Item No. **Report of the Head of Planning, Building Control, Sport & Green Spaces**

Address UNIT 5, CAXTON TRADING ESTATE PRINTING HOUSE LANE HAYES

Development: Sub-division and change of use from industrial/warehouse (Class B8) to create up to 14 industrial units for Use Class B1(c) and Class B8 with associated works.

LBH Ref Nos: **49505/APP/2013/3842**

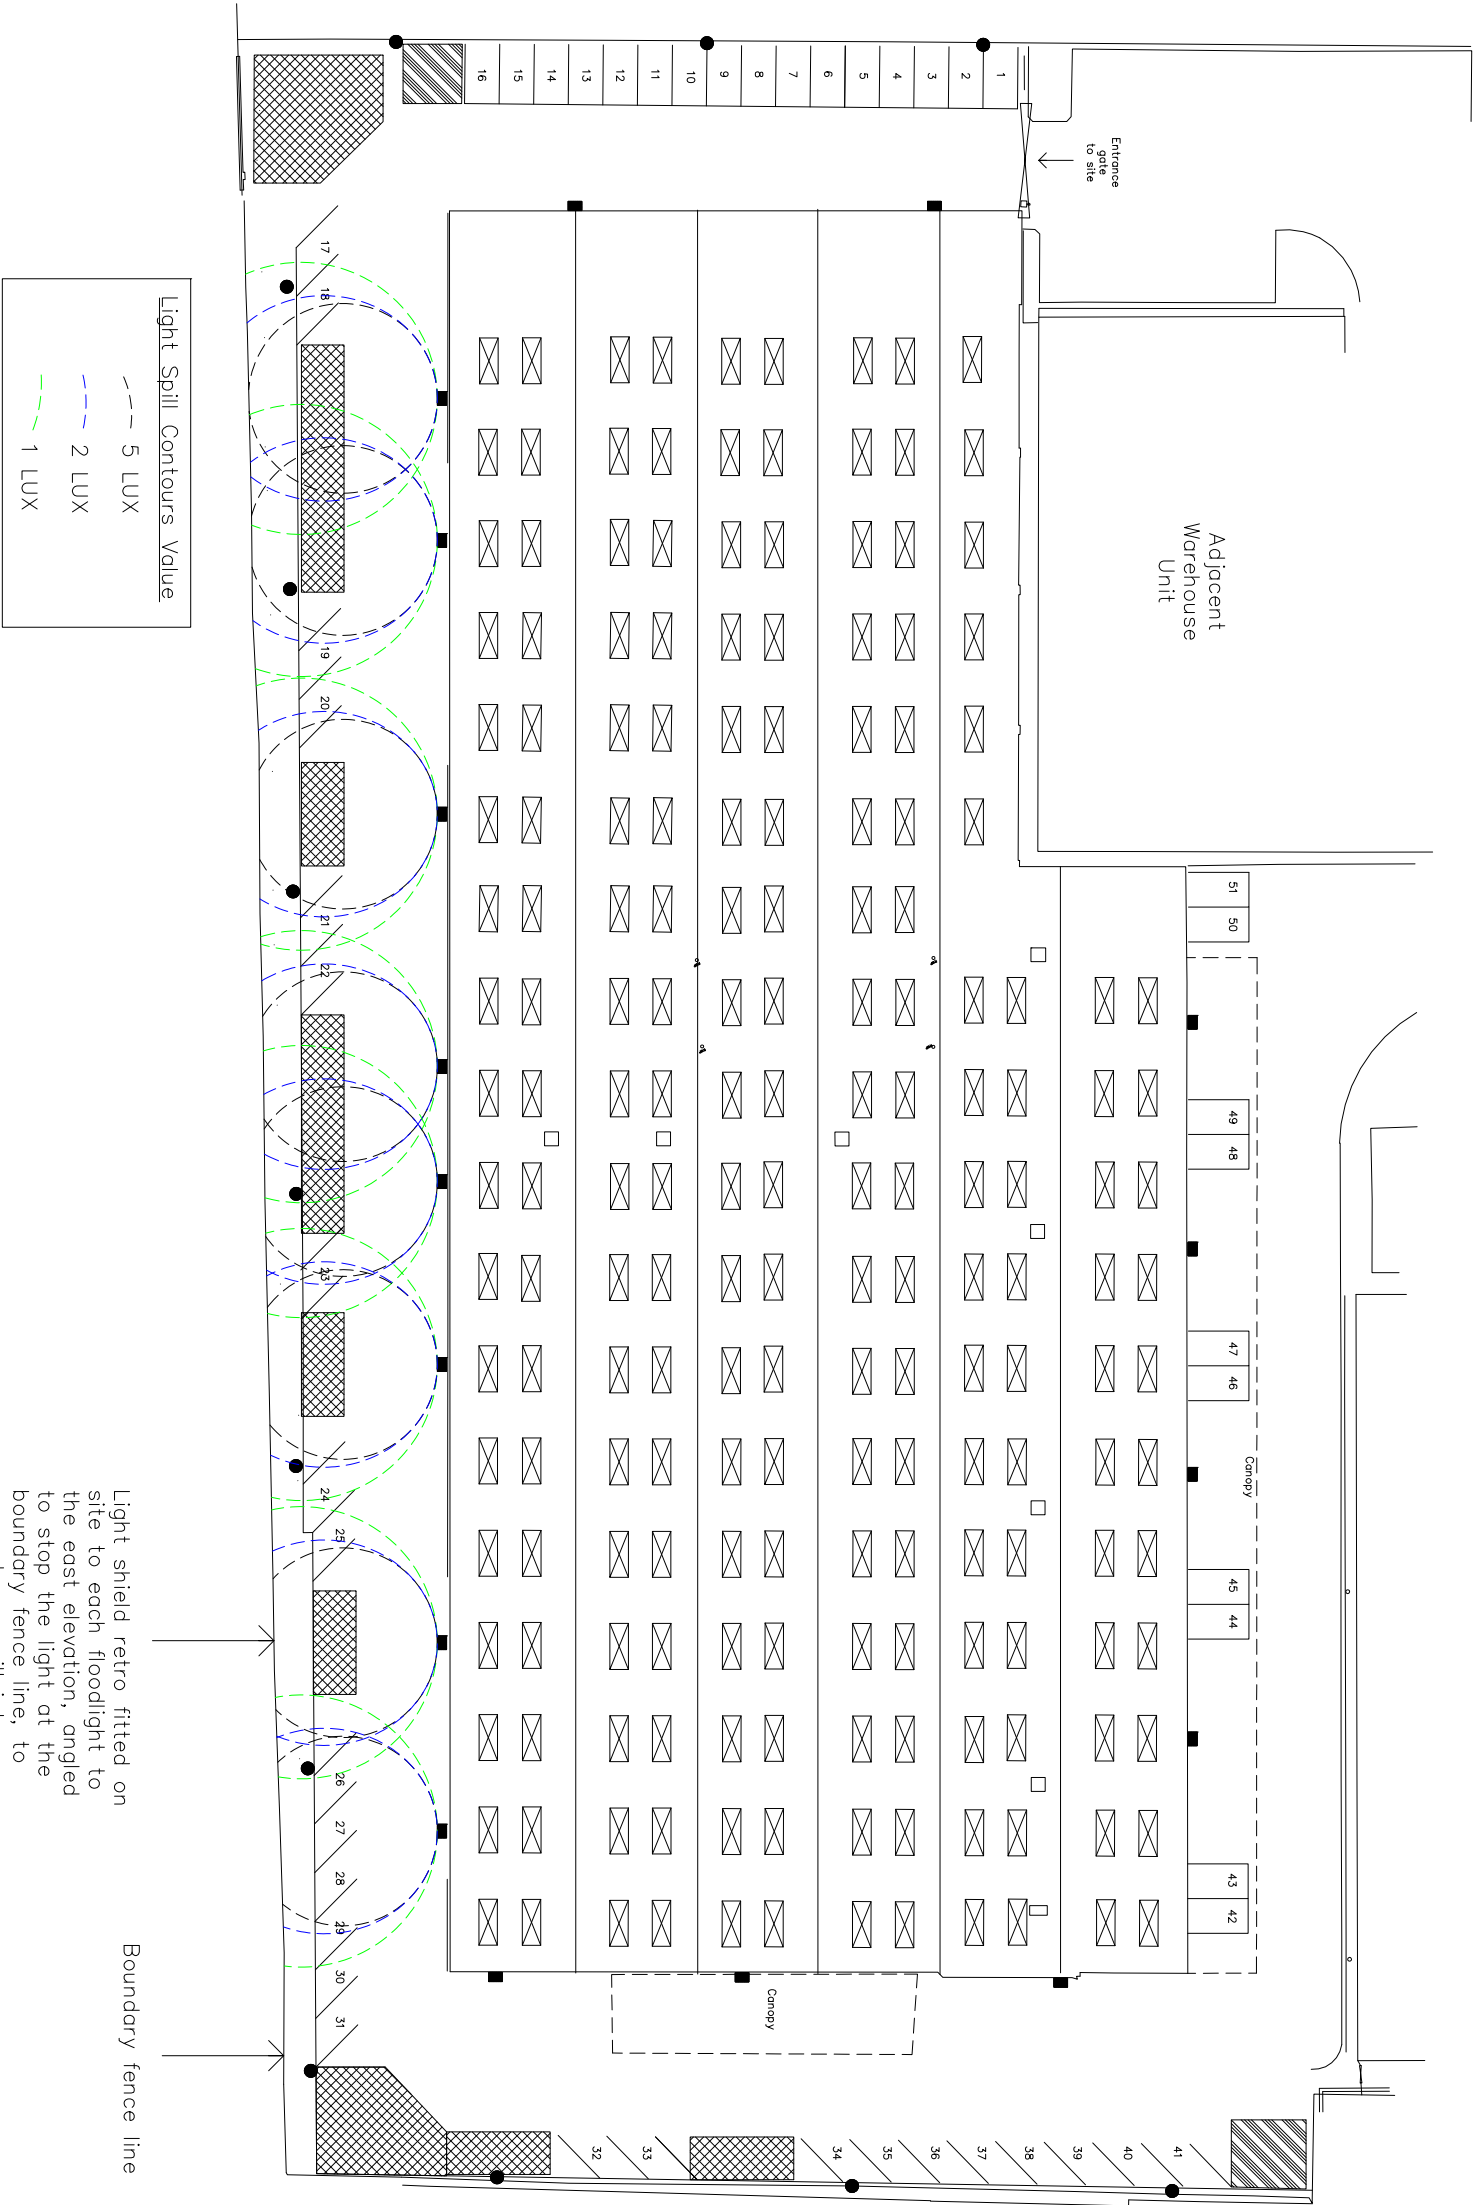
The noise report does not address delivery noise which could be quite intrusive given the row of delivery doors proposed facing the rear of the residential properties.

Proposed units 2-9 are situated in the eastern portion of the building, with the eastern elevation facing onto the rear of properties in Nield Road to the east. The front of the units serve as the accessing and servicing points for these units through roller shutter doors. There are currently only two roller shutter doors in this elevation, which serve as access points for the two existing units, with eight doors proposed to access the new units. Given the industrial use proposed within an Industrial and Business Area, it is considered that it would be inappropriate to control the use of the units (in terms of hours, and servicing, etc.) by way of condition in order to attempt to control any noise impacts. Such an approach might place unreasonable restrictions on the land reaching its full potential with regards to economic activity and job creation which could be avoided through proper design consideration, further given the number of occupiers such a condition is likely to be overly onerous in respect of some potential occupiers and would in practical terms be impractical/unenforceable across such a variety of separate occupiers.
